Locomotive Workshop, Bays 1-4a

○ *State Significant
Development Modification
Assessment
(SSD 8517 MOD 5)*

February 2020

Figure 1: Heritage arched window – external view (Source: Curio Projects, 2015)

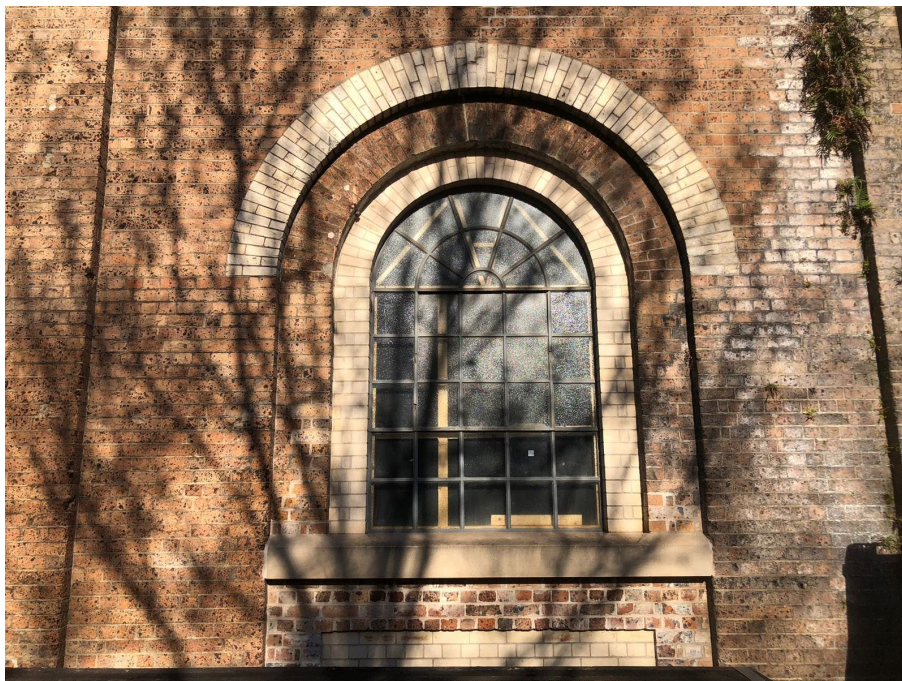
The Applicant seeks to change Condition B44 to allow frosted glazing to be installed in the existing heritage arched windows within the Locomotive Workshop, instead of clear glazing. The Applicant advises a significant amount of the early and original glass panels of the heritage arched windows are frosted, are in poor condition and require replacement (**Figure 4**).

A statement from the Applicant's Heritage Consultant advised that replacing the glass with clear panes would be inconsistent with the original windows and recommended changing the condition to allow frosted glazing to be installed to maintain the integrity and original quality of the windows.

Council reviewed the proposal and recommended the term 'frosted' be used instead of 'opaque' or 'tinted', which the Applicant has agreed with. Heritage NSW reviewed the proposal and raised no objections.

The Department supports the change to Condition B44 as:

- clear glass panels would be inconsistent with the original windows
- the use of 'frosted' glazing will maintain the heritage quality of the windows and accurately describes the type of glass to be replaced
- frosted glazing will only be permitted in existing heritage arched windows, will match the existing frosted glazing and will occur in consultation with the project's heritage consultant.

On this basis, the Department's assessment concludes the use of frosted glazing instead of clear glazing is acceptable.

C_STAGINGPLAN_4
CIVIL WORKS STAGING PLAN
DATE: 21/01/20
REVISION: 4

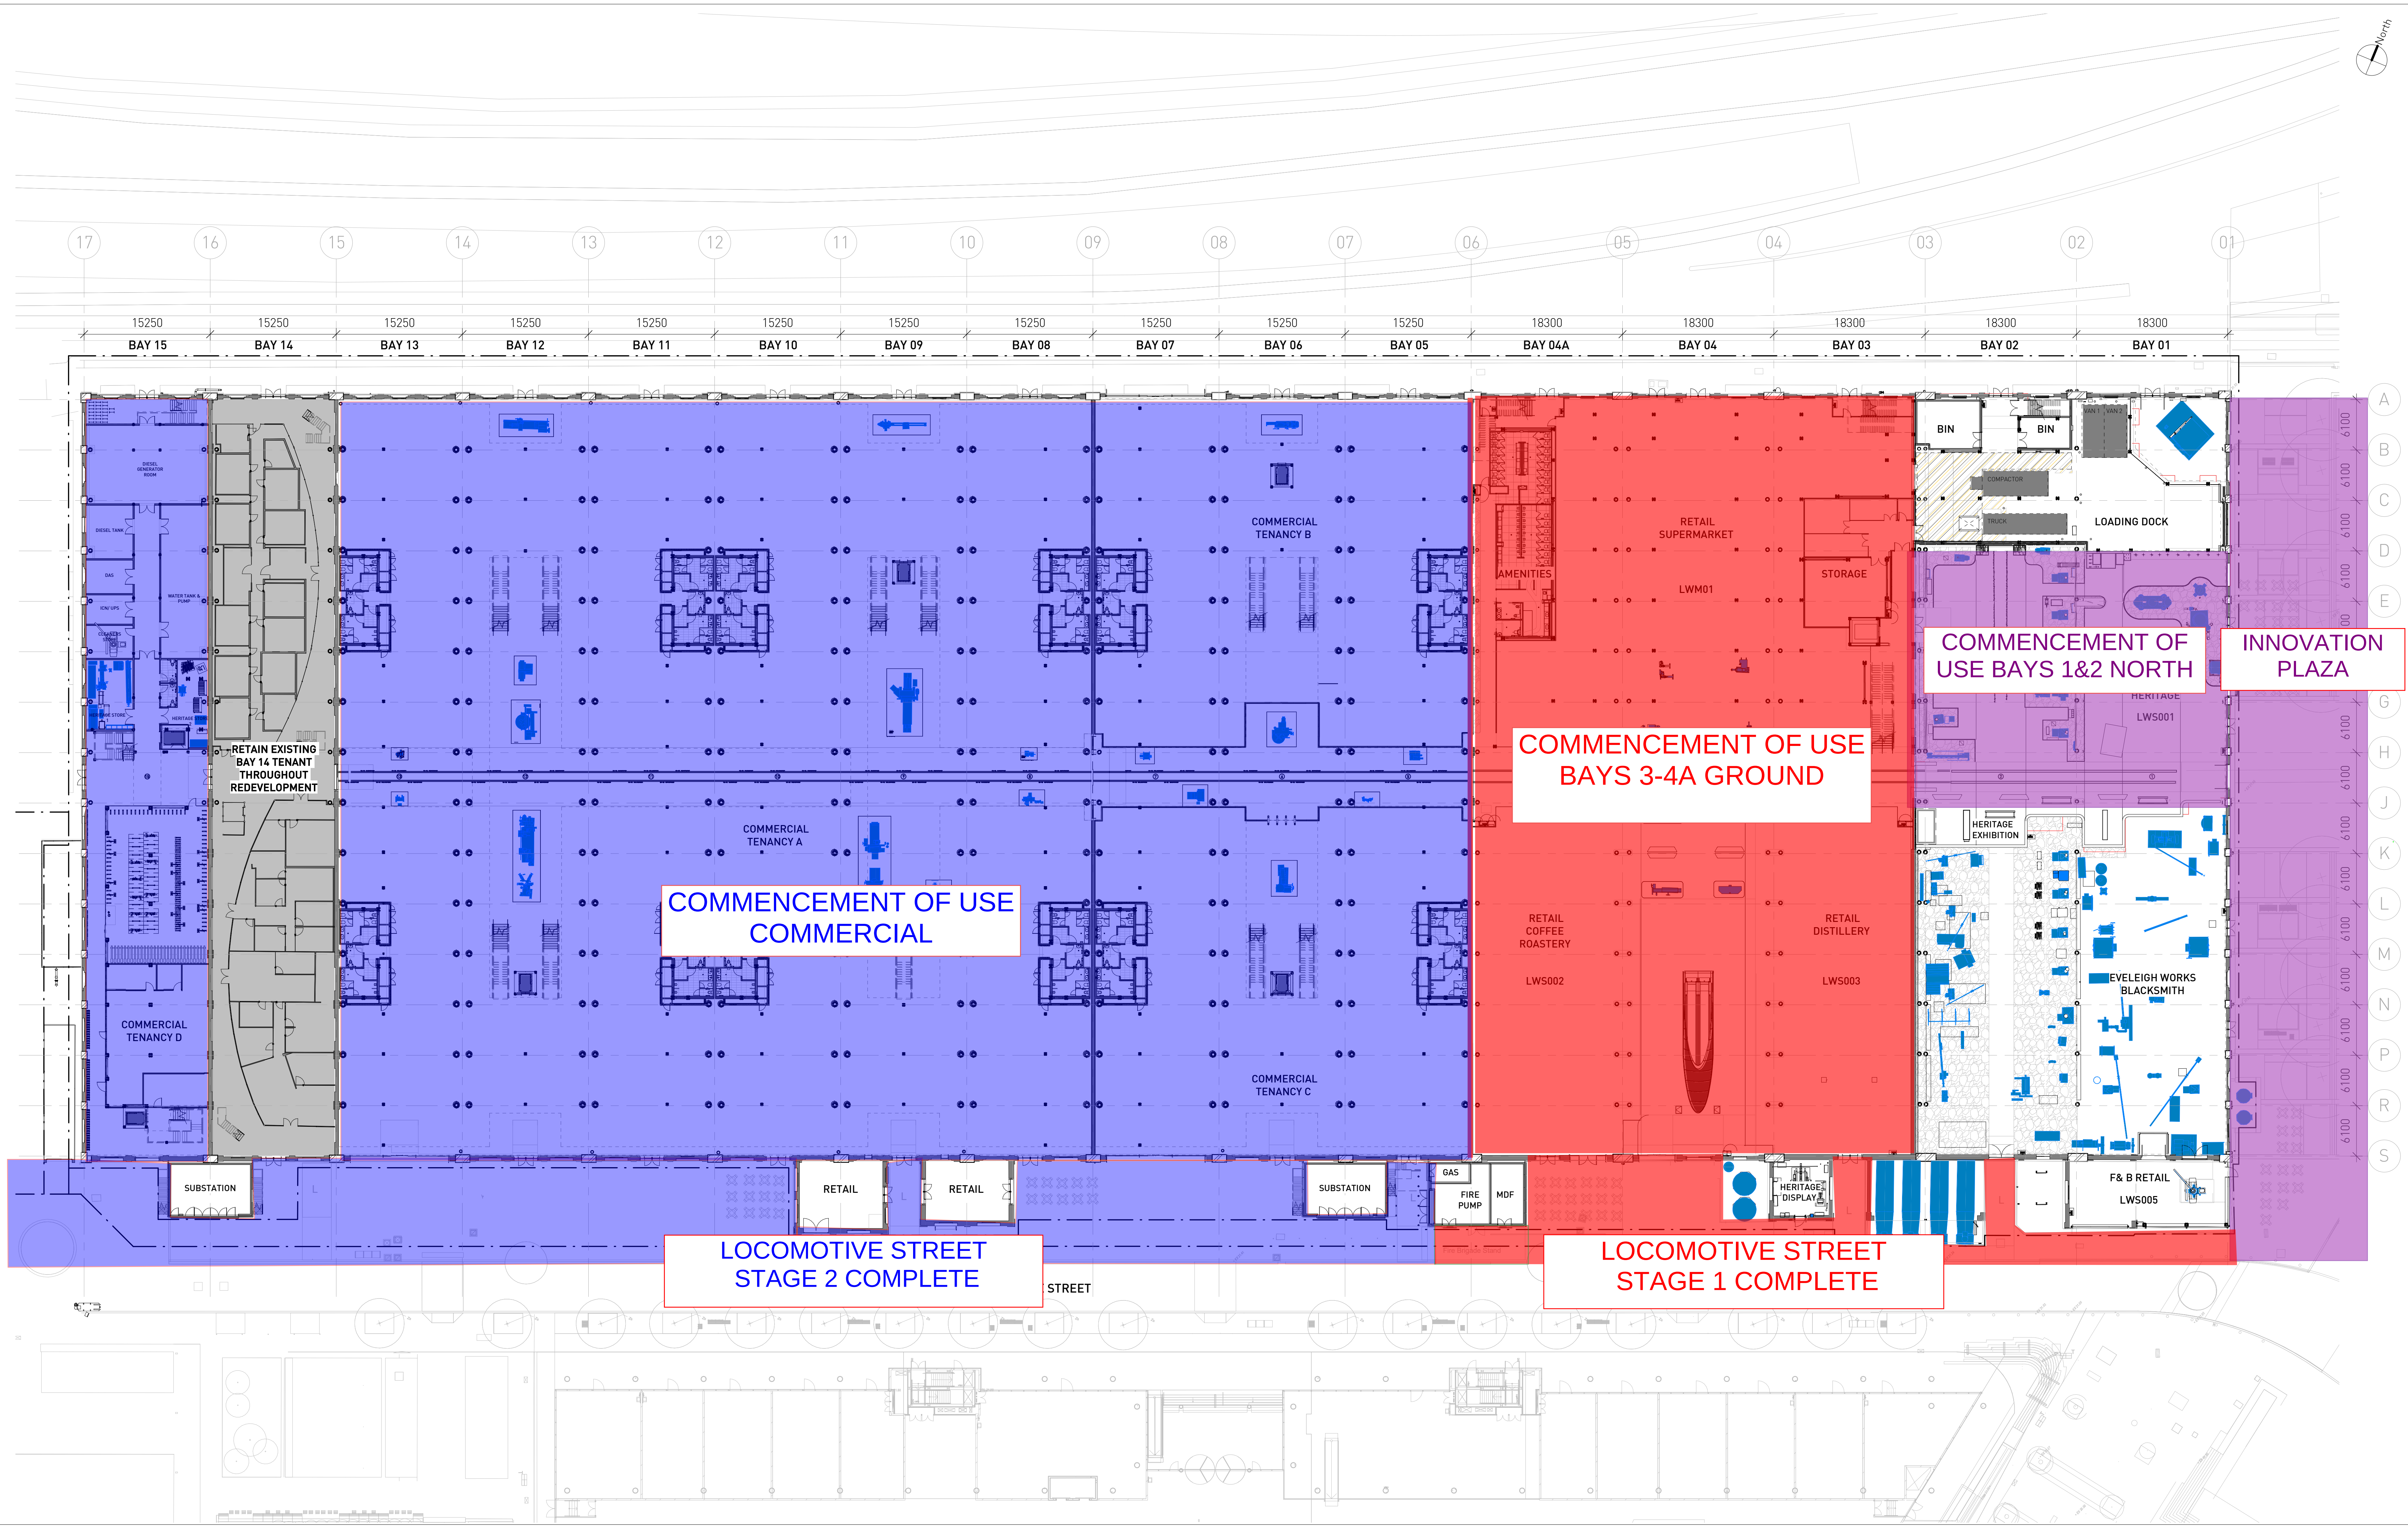
The Department requested the Applicant reconsider the wording of Condition E9 (Public Domain Works), noting the indicative staging plan is inconsistent with the proposed wording of the condition.

The Applicant seeks to change the timing for completion of the public domain works to enable staged delivery of Innovation Plaza and Locomotive Street (Stage 1 and Stage 2) in accordance with the Civil Works Staging Plan prepared by Mirvac (**Figure 3**). Currently the condition requires completion prior to the commencement of use or issue of the first Occupation Certificate.

- Innovation Plaza: prior to commencement of the use of Bays 1 & 2
- Locomotive Street Stage 1: prior to commencement of the use of Bays 3-4a (ground level)
- Locomotive Street Stage 2: prior to commencement of the use of Bays 5-15.

The Department also notes that currently the public domain works must be completed prior to the first occupation certificate for Bays 1-4a, which is due to be completed while construction works are still occurring within Bays 5-15. This construction sequencing is problematic as it requires all public domain works to be completed while construction within the larger portion of the building (Bays 5-15) is still occurring. In addition, the Department notes potential for damage to the new public domain if it is completed before construction works have been finalised.

The Department supports the Applicant's proposed staged delivery of public domain for the following reasons:

The Department therefore recommends Condition E9 be updated to refer to the timing of delivery of the public domain as shown in the Civil Works Staging Plan.
